Historic England

29 March 2021

Arrangements for Handling Heritage Applications Direction 2015

20-22 TALBOT STREET, CHIPPING, PR3 2QE
Application No. 3/2020/0763

Title: **FLOOR PLANS AND SECTIONS PROPOSED LAYOUT**

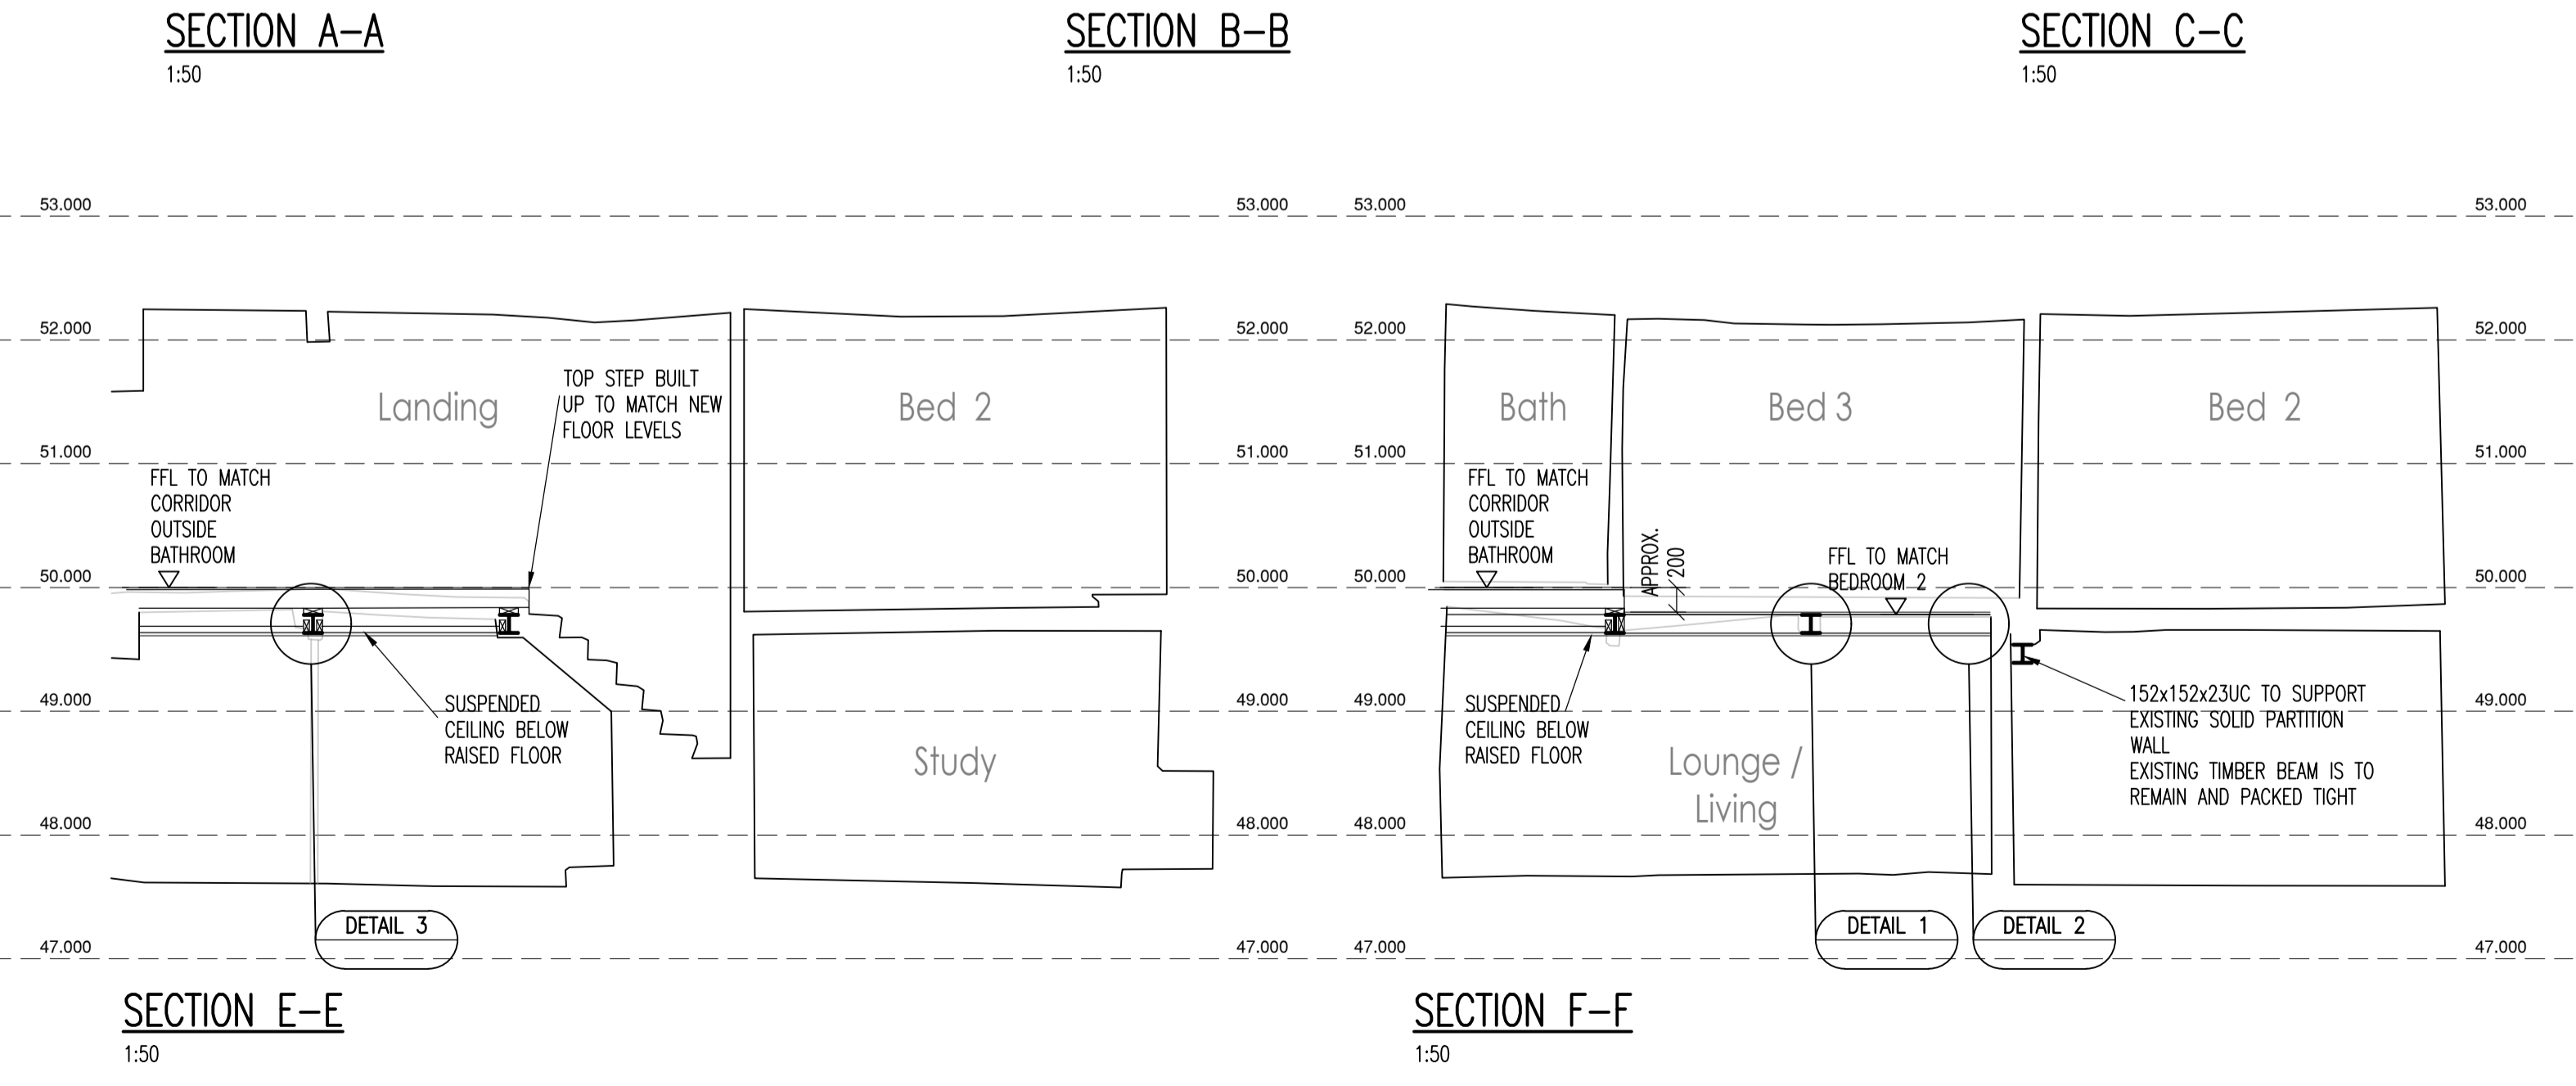
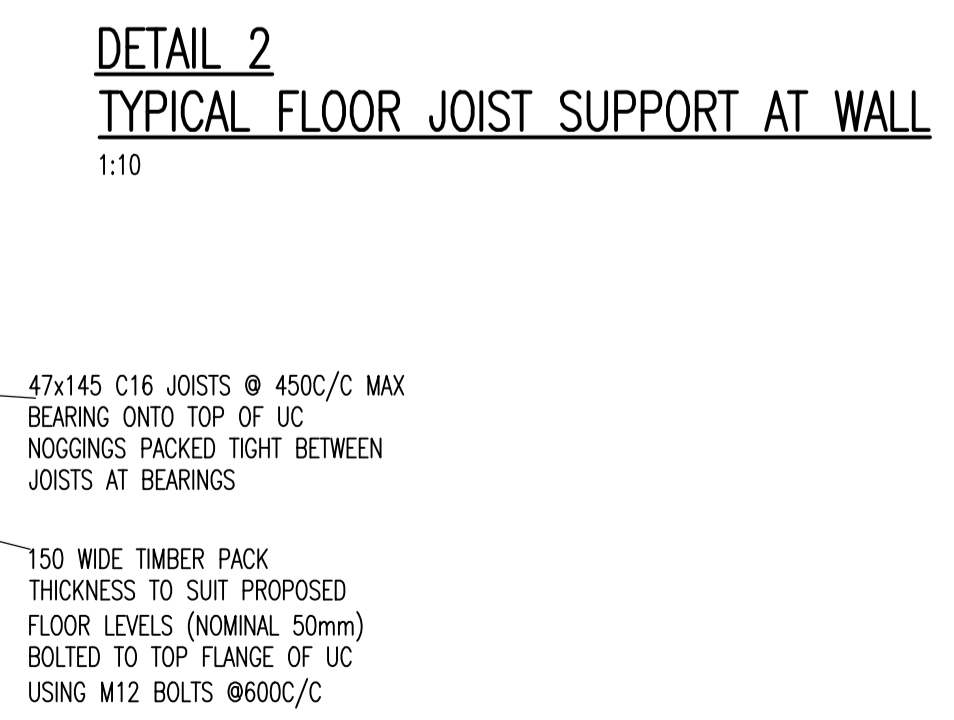
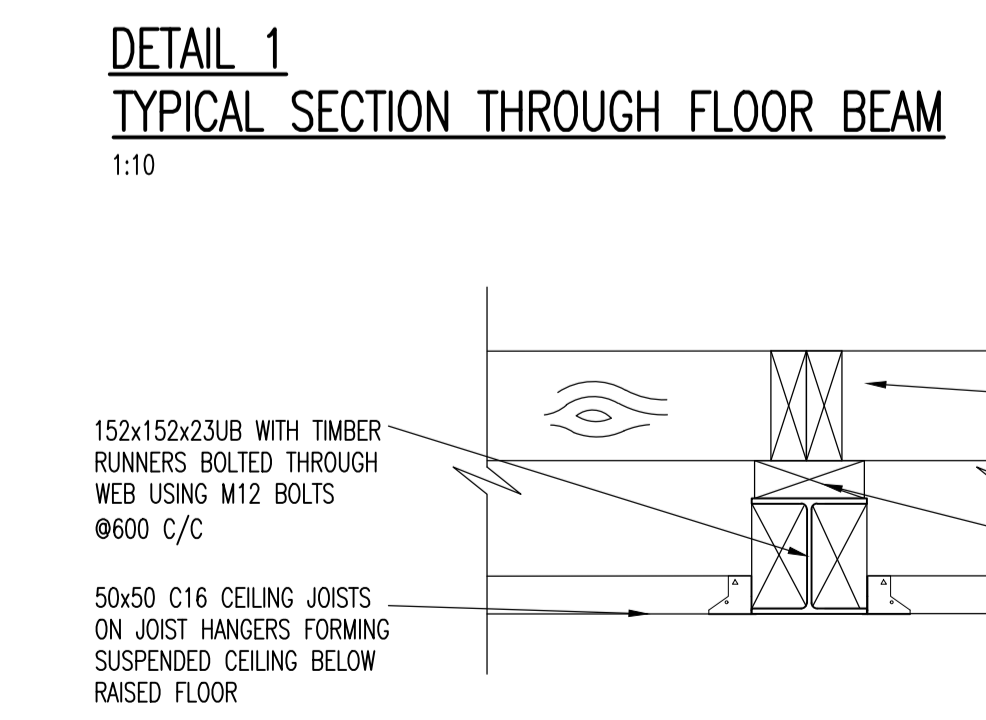
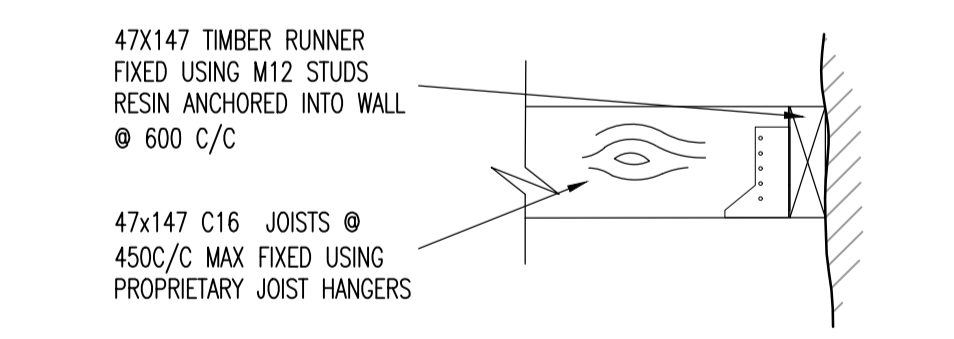
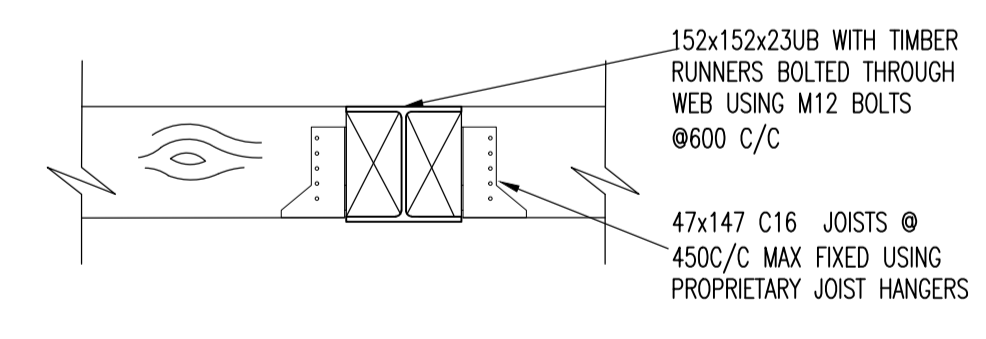
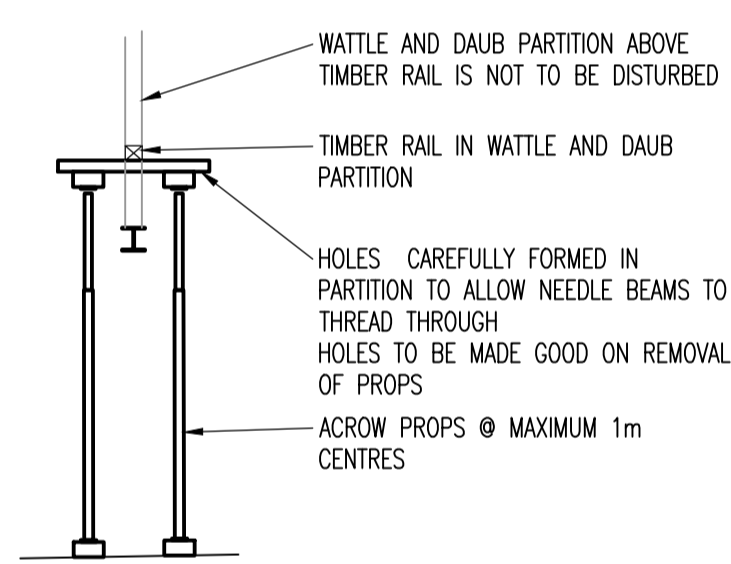
Proposals now seek to insert steel channel either side of the first floor wattle and daub partition within the first floor void. It is understood that these new steels will take the weight of the partition and the loads that it carries instead of the defective timber beam (Beam 1), the steels will in effect render the timber beam structurally redundant. In order to secure the retention of the timber beam it is proposed to install a series of steel hangers from the new steel channel above to support to support the beam below.

Originally the proposals also included the replacement of Beam 2 as it is displaying some signs damage. However, the revised proposals now include the retention of this potentially original beam and instead pack the shakes in the beam with oak secured by coach bolts.

However, we remain unsure how the new steel channels will interact with and support the historic wattle and daub partition, to this end we recommend that the Local Planning Authority secure these details, possibly as a method statement, via a condition.
